Rezoning Transportation Analysis

Petition Number: 2022-147

| Date | Description |
|----------|--------------------|
| 1-25-23 | First Review (IW) |
| 03-22-23 | Third Review (IW) |

RZ-101

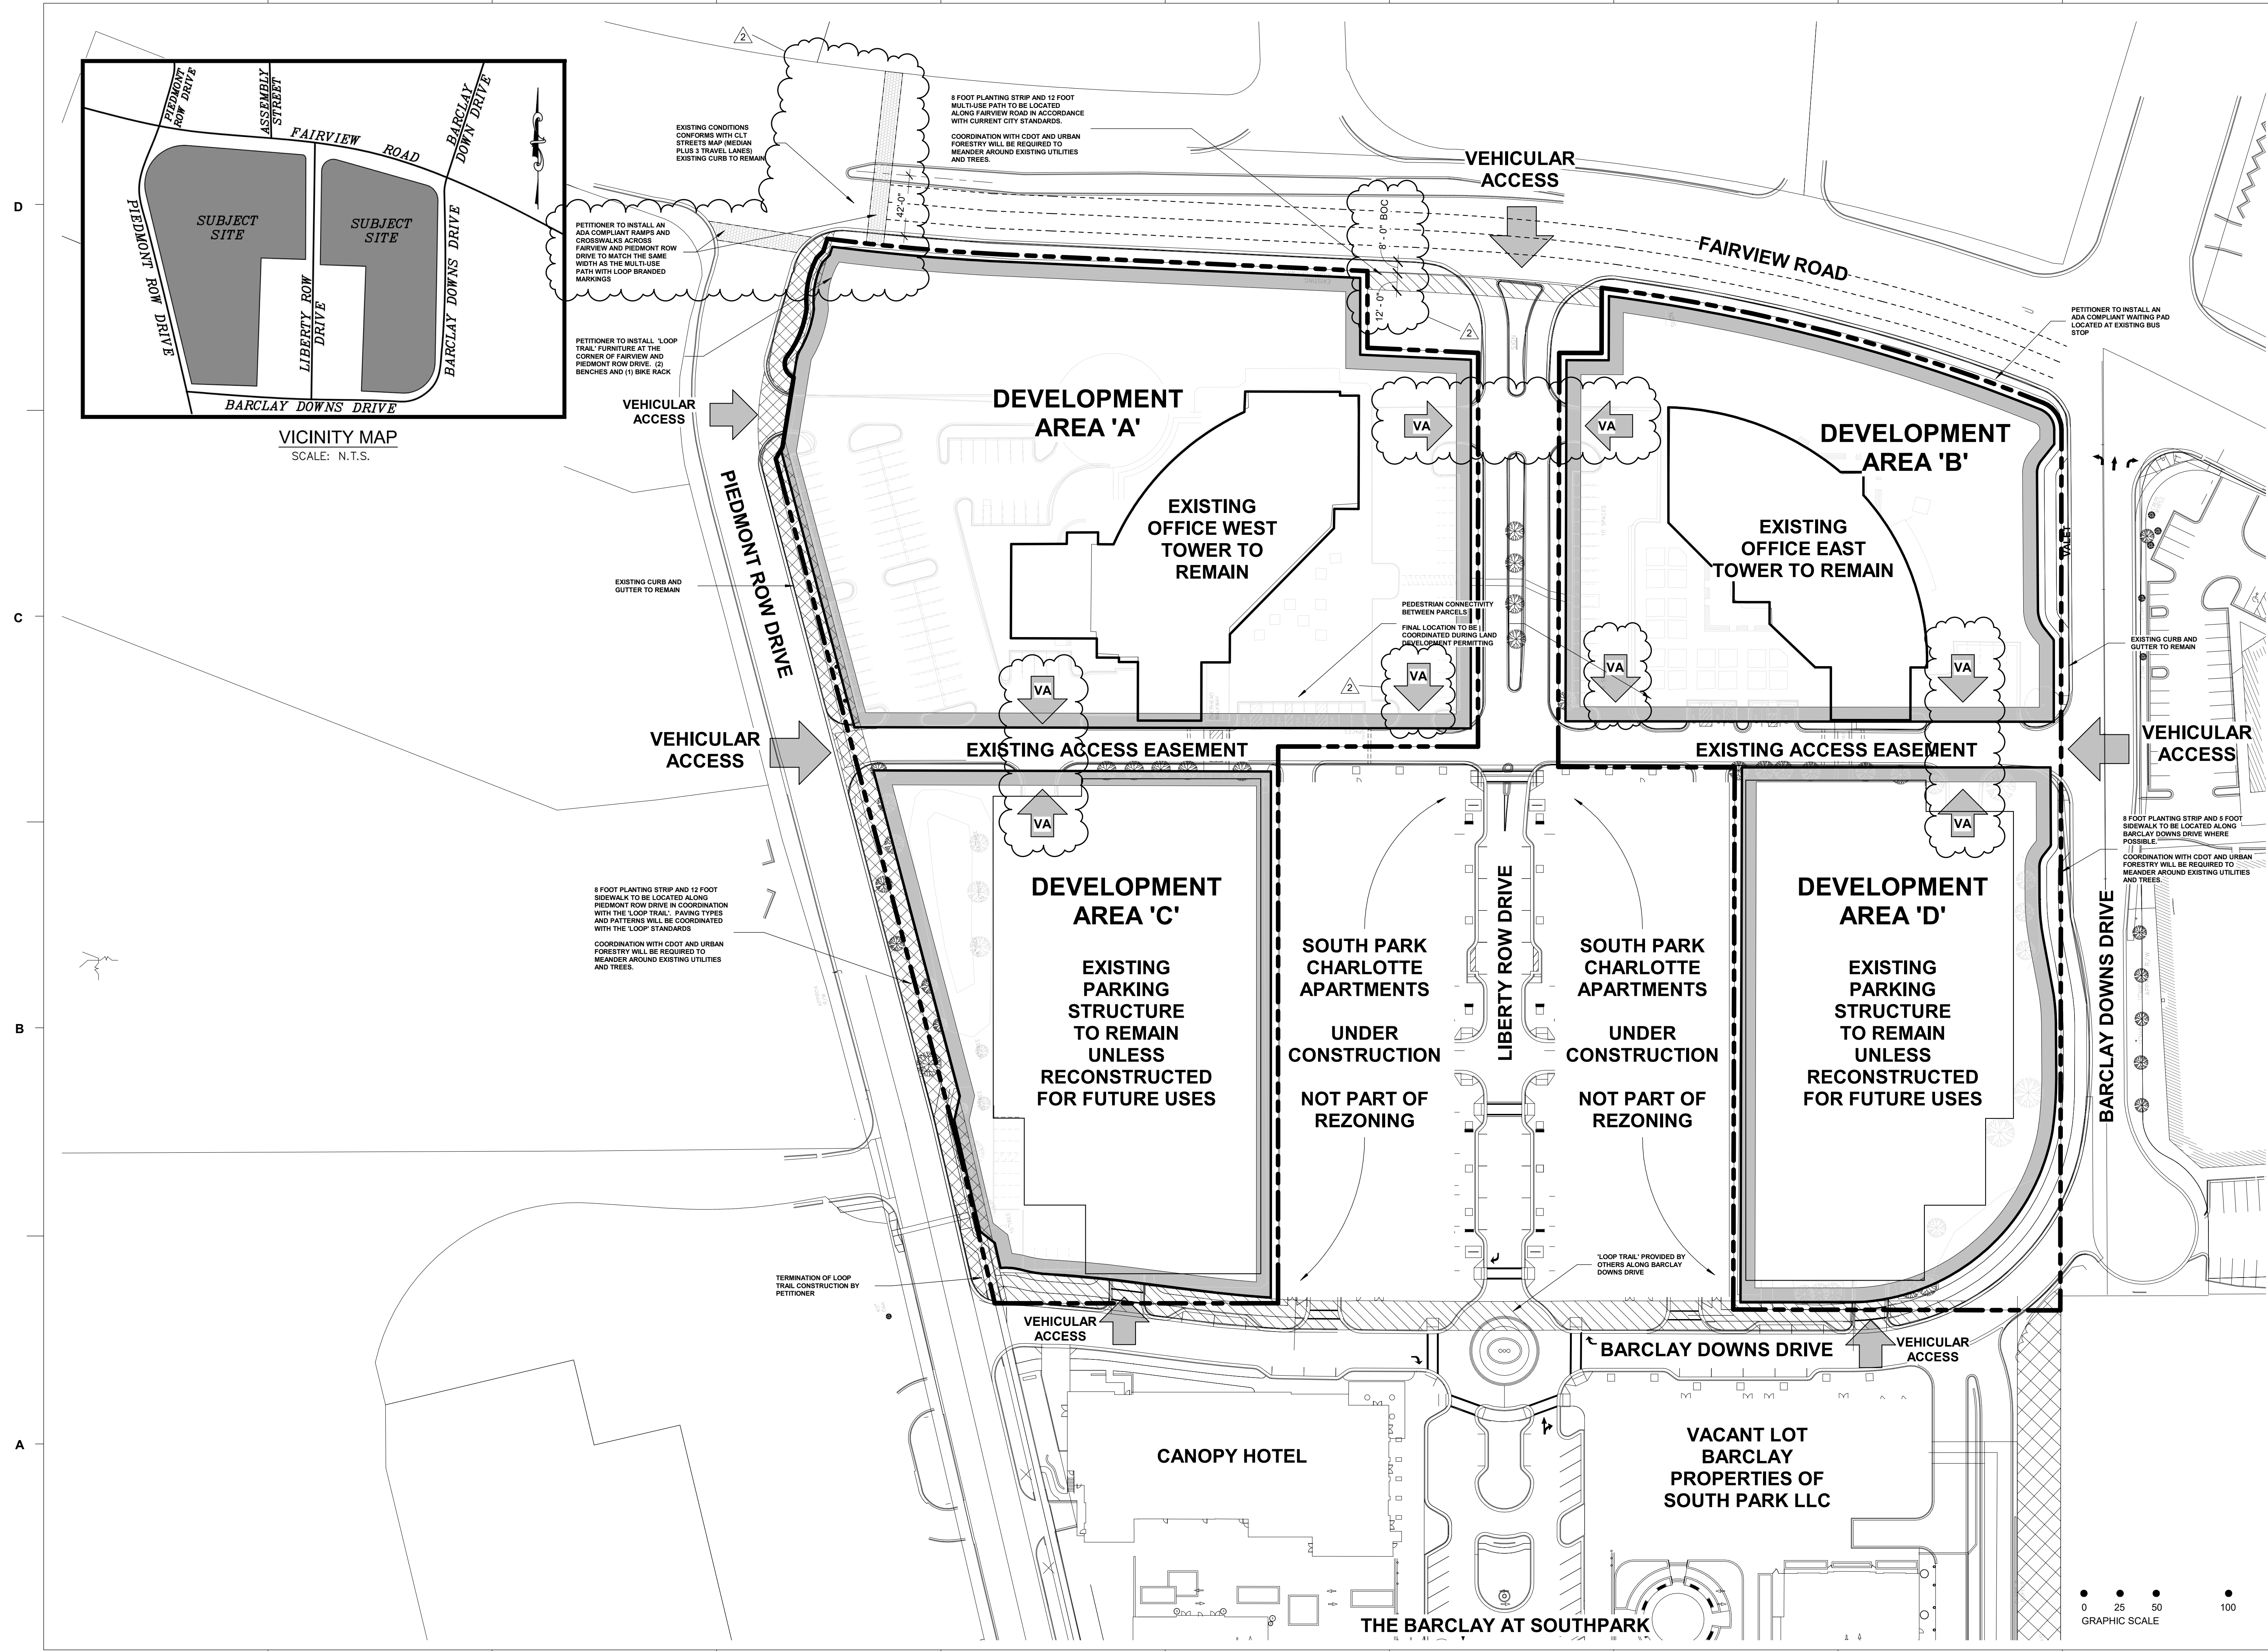
- Outstanding Comment from 1-25-23** Revise site plan and conditional note(s) to commit to dedicate 63 feet of right-of-way from the Fairview Road centerline. The site plan shall label and dimension the right-of-way from the road centerline.

11. **New Comment 2-22-23:** In order to comply with federal ADA requirements, the ramps and crosswalk(s) across Fairview Road and Piedmont Row Drive will need to be reinstalled so that the width is the same as the Multi-Use Path(s) the petitioner has agreed to install. A note should be added to install the crossing across Fairview Road with Loop Brand crosswalk markings.

Clarifying Comment 3-22-23: Update conditional note V.d.ii.iii. to change "WB" to "EB" as the southern crosswalk is along the eastbound direction on Fairview Road.
